Ann Machado - 72 Westminster Ave. - Permit #2014-00179 - ADA handicap accessible ramp

From: Ann Machado
To: CScripture@customfloat.com
Date: 1/31/2014 10:27 AM
Subject: 72 Westminster Ave. - Permit #2014-00179 - ADA handicap accessible ramp
Attachments: Fast Track Permit (Revised 11_21_13).pdf

JACOBSON SITE PLAN  
72 WESTMINSTER AVE PORTLAND, ME  
PERMIT APPLICATION

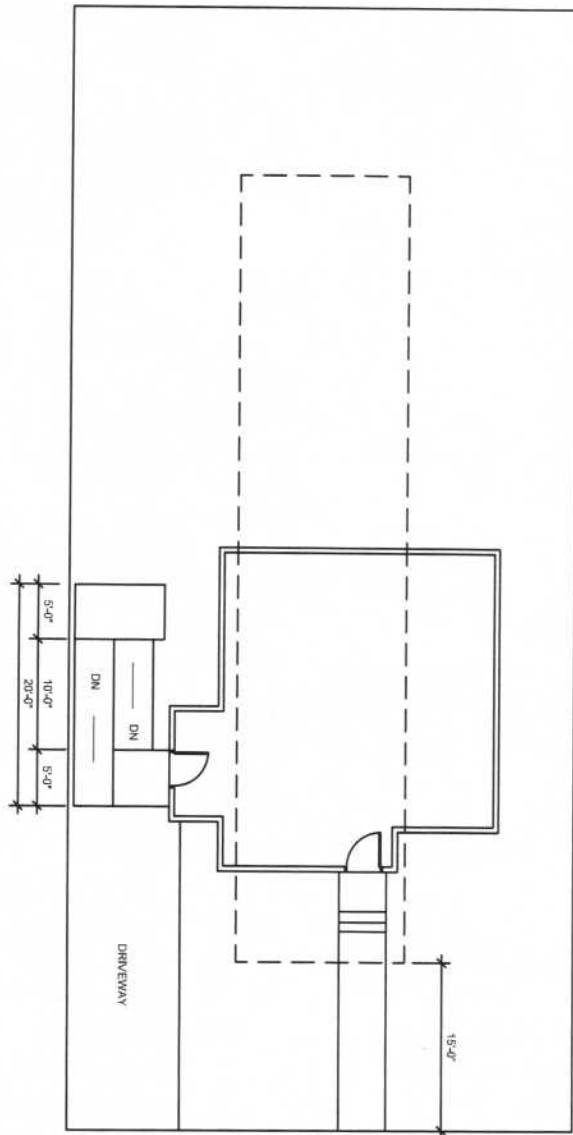
Second, I need more information on the actual sizes of the landings and ramp sections. The site plan shows the length of the two long ramps as 10' but what are their widths? Also what are the exact sizes of the two landings - one by the door and the one midway?

Third, I need to know what the exact setback is to the side property line and what the setback is to the rear property line for the proposed ramp.
